CPRE, The Countryside Charity, Oxfordshire

14th July 2022

Re Noke Solar Farm application 22/01682/F

Land at Manor Farm,  
Noke, Oxfordshire  
**Illustrative Landscape  
Sections A-C**

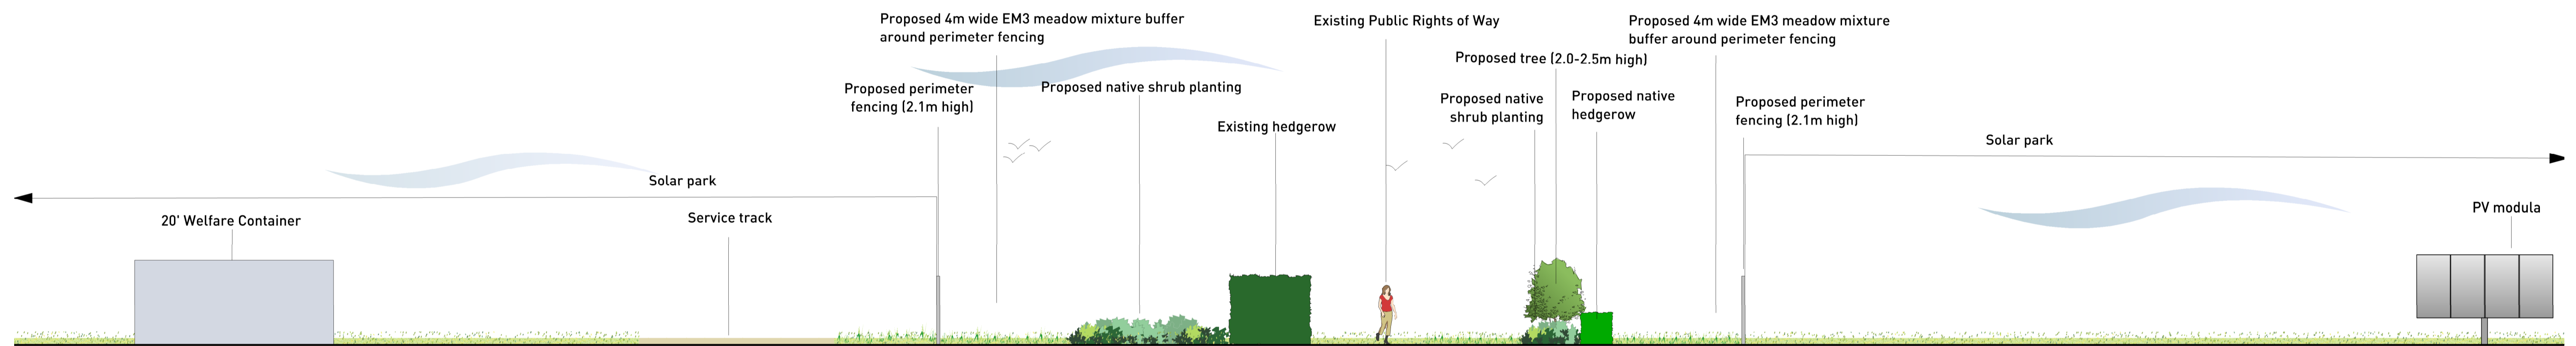
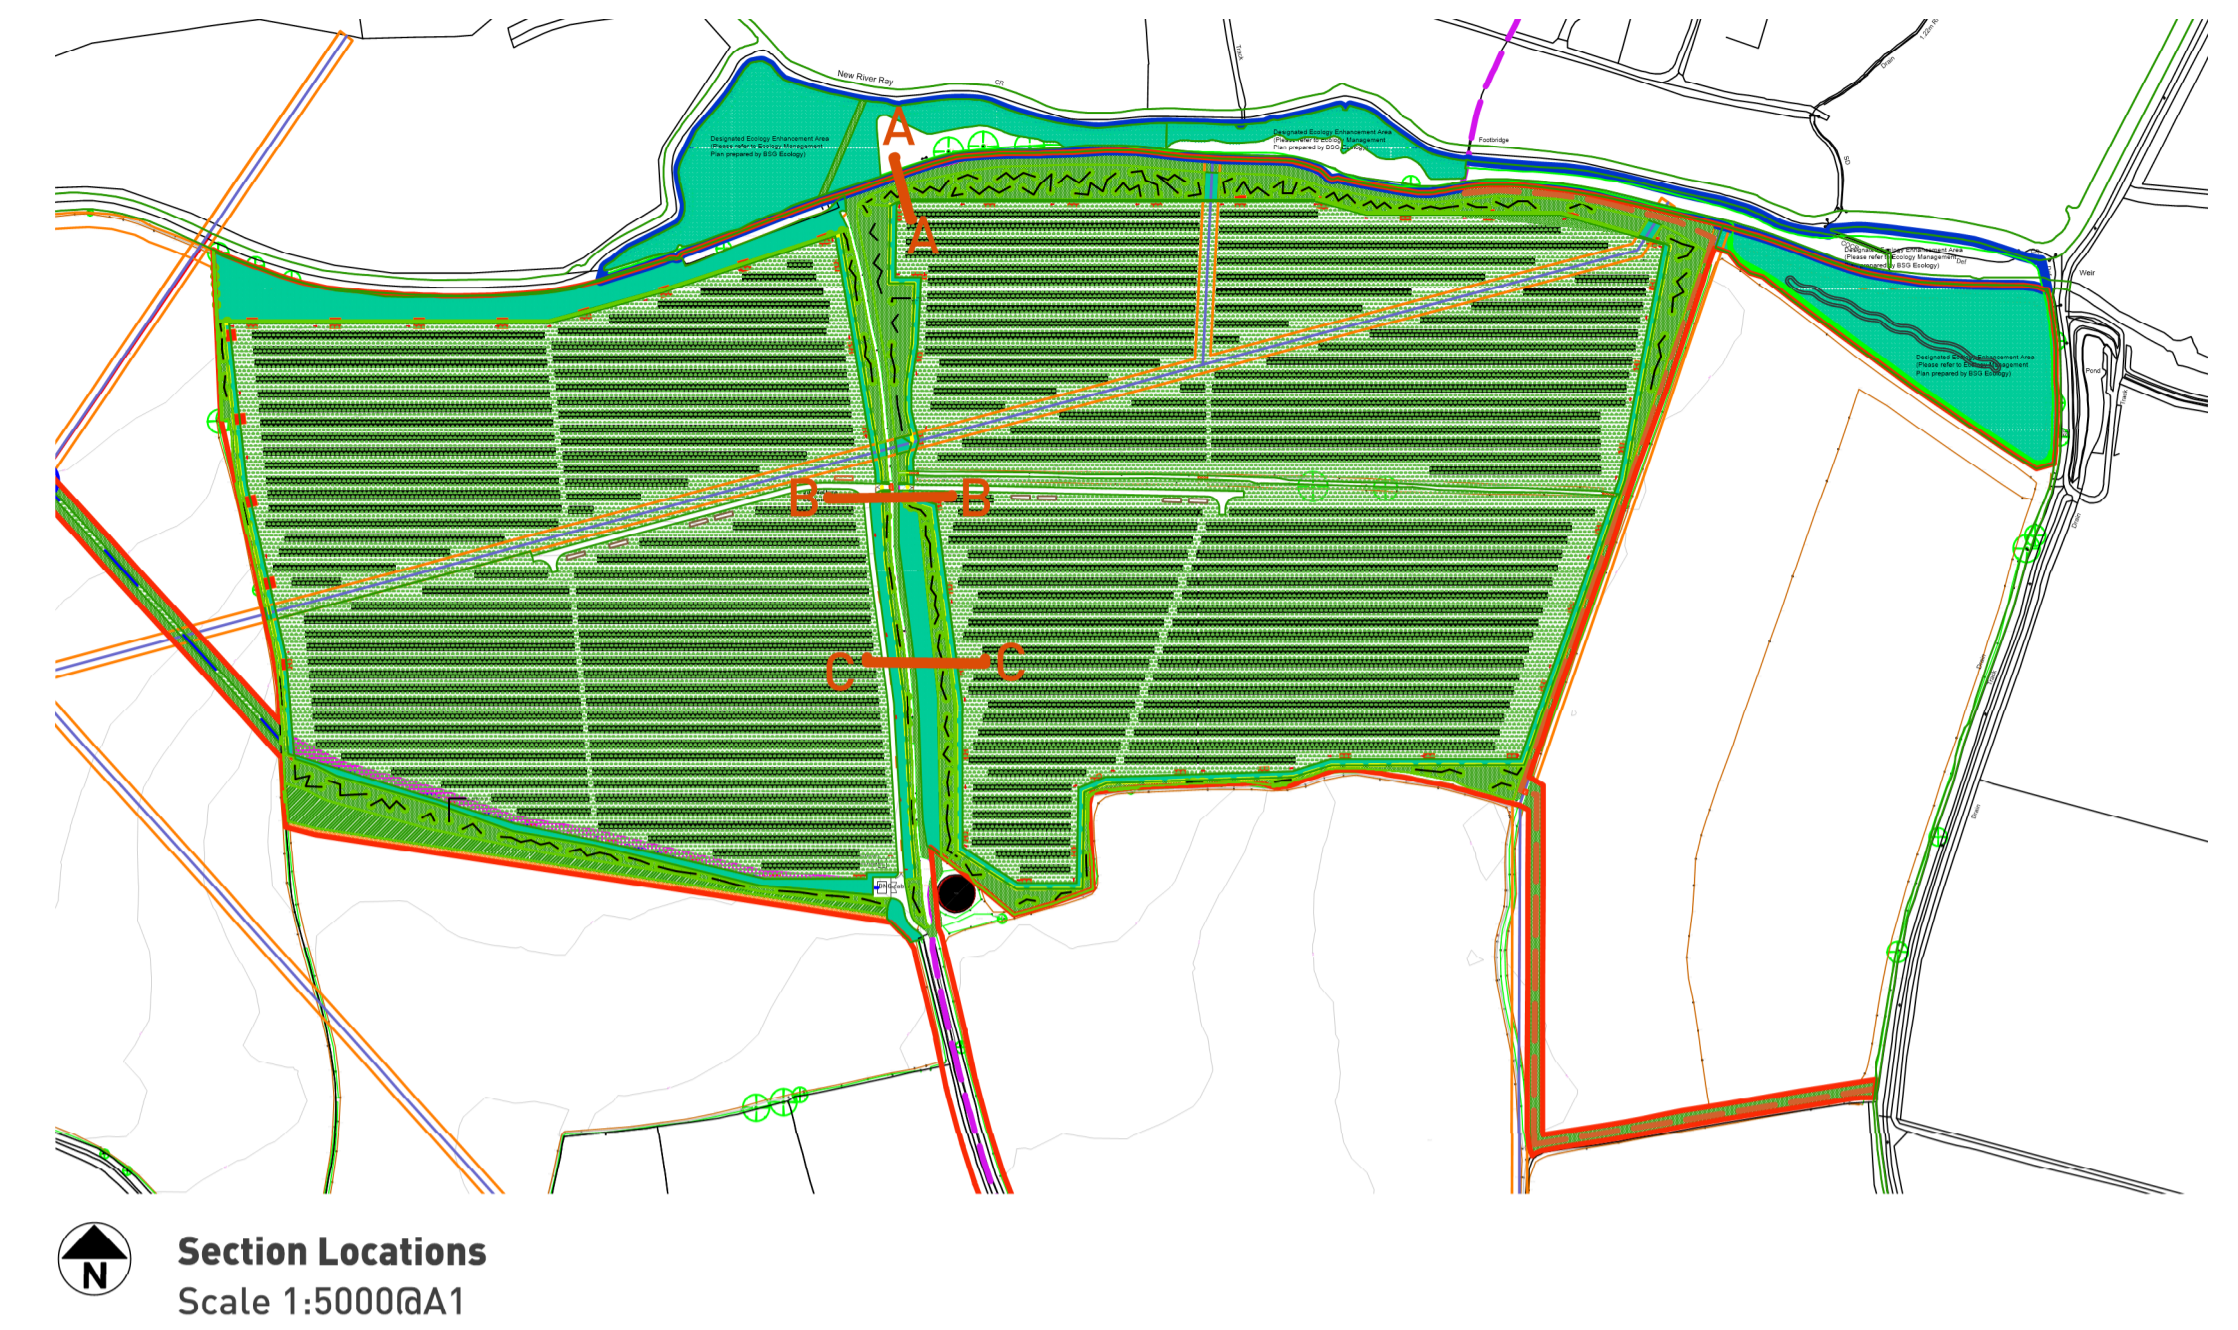
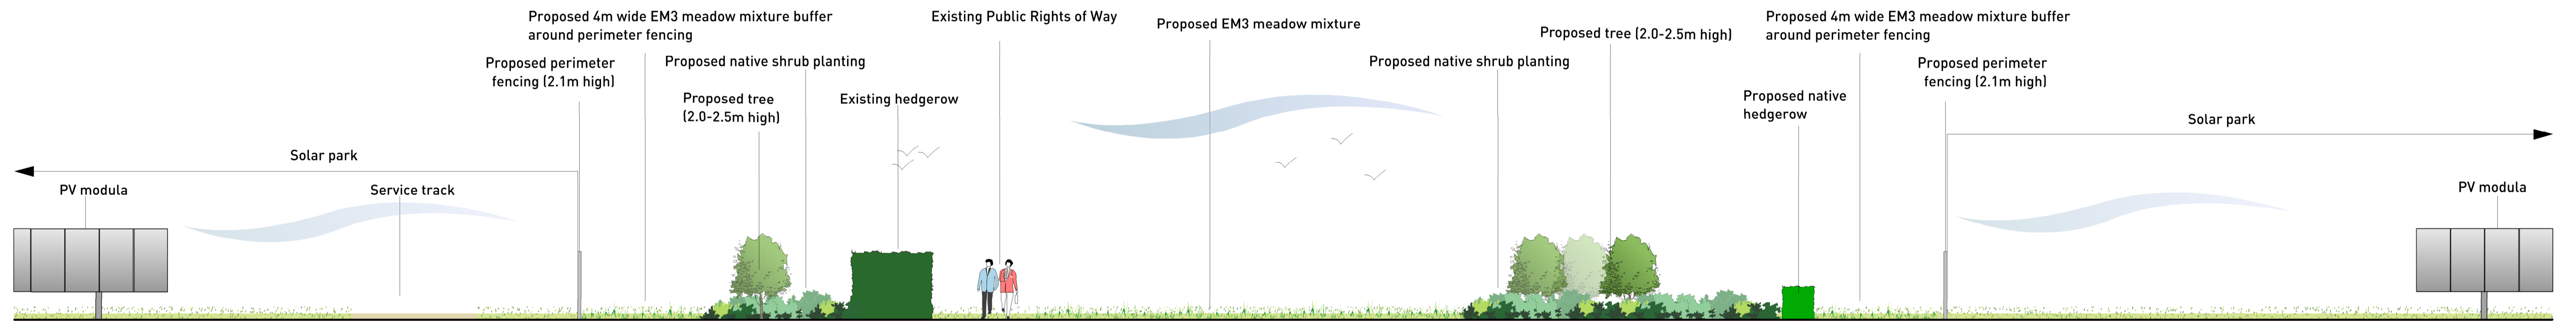
If the development were to be permitted, all the views into the valley would be blighted with inappropriate industrialisation, which it is not possible to satisfactorily shield, and views out of the site and from its public footpath across the countryside and towards the surrounding ridge would be blocked with nine foot hedging – itself inappropriate developmen

project whilst doing nothing to conceal it. Conversely it would entirely eliminate the present wide views from the public right of way, effectively confining walkers to a green tunnel, instead of the wide vistas of waving grain and hilltop villages they now enjoy.

To some extent these effects could be reduced by choosing loose deciduous hedging rather than suburban evergreen, but then the panels would not be concealed at all for the winter months, half the year, from the footpath within the site.

THE PATH WILL RETAIN A WIDE OPEN FEEL AND VIEWS OF HILLTOP VILLAGES WILL BE ENTIRELY UNOBSTRUCTED. THE PATH DOES CURRENTLY ENTER A CORRIDOR BETWEEN TWO HEDGES SOUTH OF THE PROPOSED SITE BUT THIS ATTRACTS NO CRITICISM

THE HEDGING IS PRINCIPALLY DECIDUOUS BUT THIS PROVIDES PRETTY GOOD SCREENING IN WINTER
